Office of Environment & Heritage

RE: Bodangora Wind Farm Project (10_0157)

The Office of Environment Heritage (OEH) has reviewed the exhibited Environmental Assessment for the Bodangora Wind Farm Project, and provides the following submission at Attachment A - Biodiversity for consideration by the Department of Planning and Infrastructure.

ATTACHMENT A

**Figure 2. Layout of the Bodangora Wind Farm.**

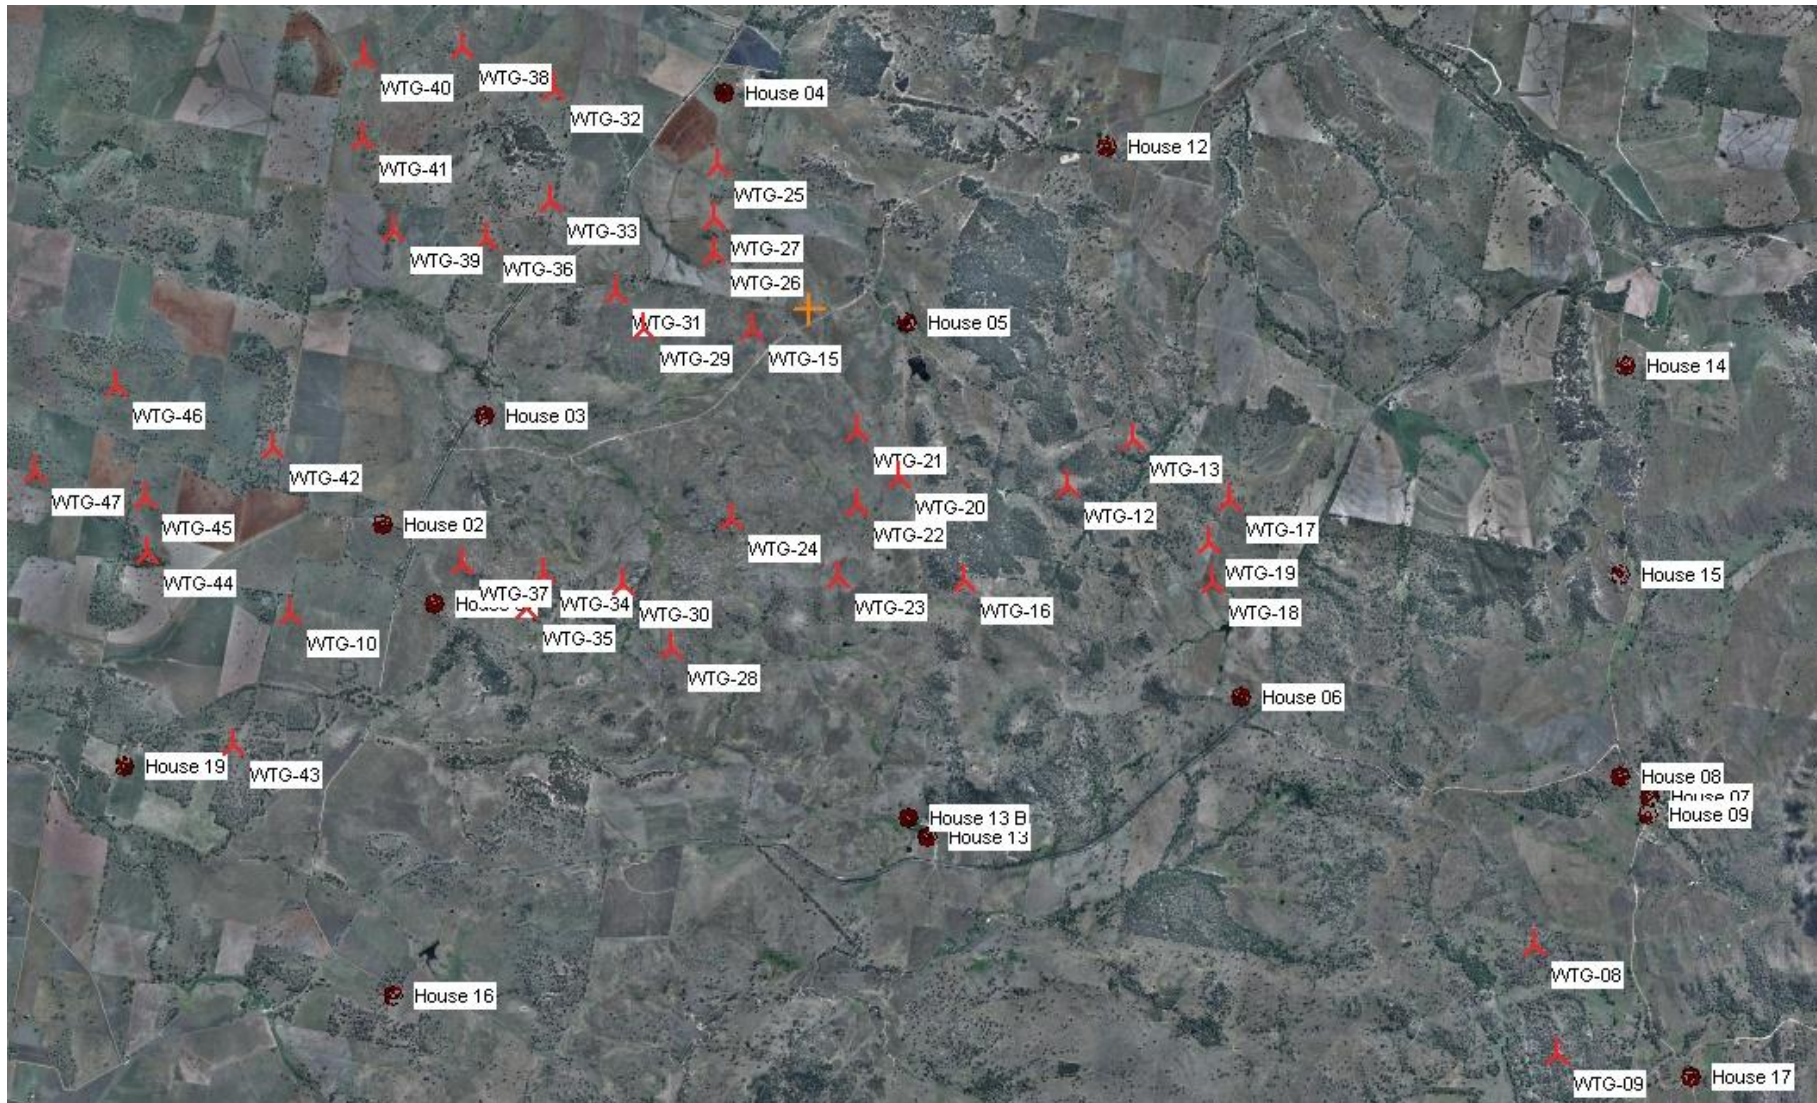
There is no vegetation map that could be used to independently assess impact and avoidance. The EA suggests that "*The general extent of the woodland and remnant tress can be appreciated in Figure 2.*" Figure 2 is either Landsat imagery or aerial photography and the vegetation is not delineated. As such, no firm conclusions can be drawn as to the nature, or extent, of any impact to vegetation. If anything, Figure 2 suggests that there may be greater than the 1.32ha loss of native vegetation suggested in the EA.

- include details of the site selection assessment of all infrastructure with regard to ecological considerations; and
- consider the potential for *Z. obcordata* to occur on site and conduct surveys for this species.
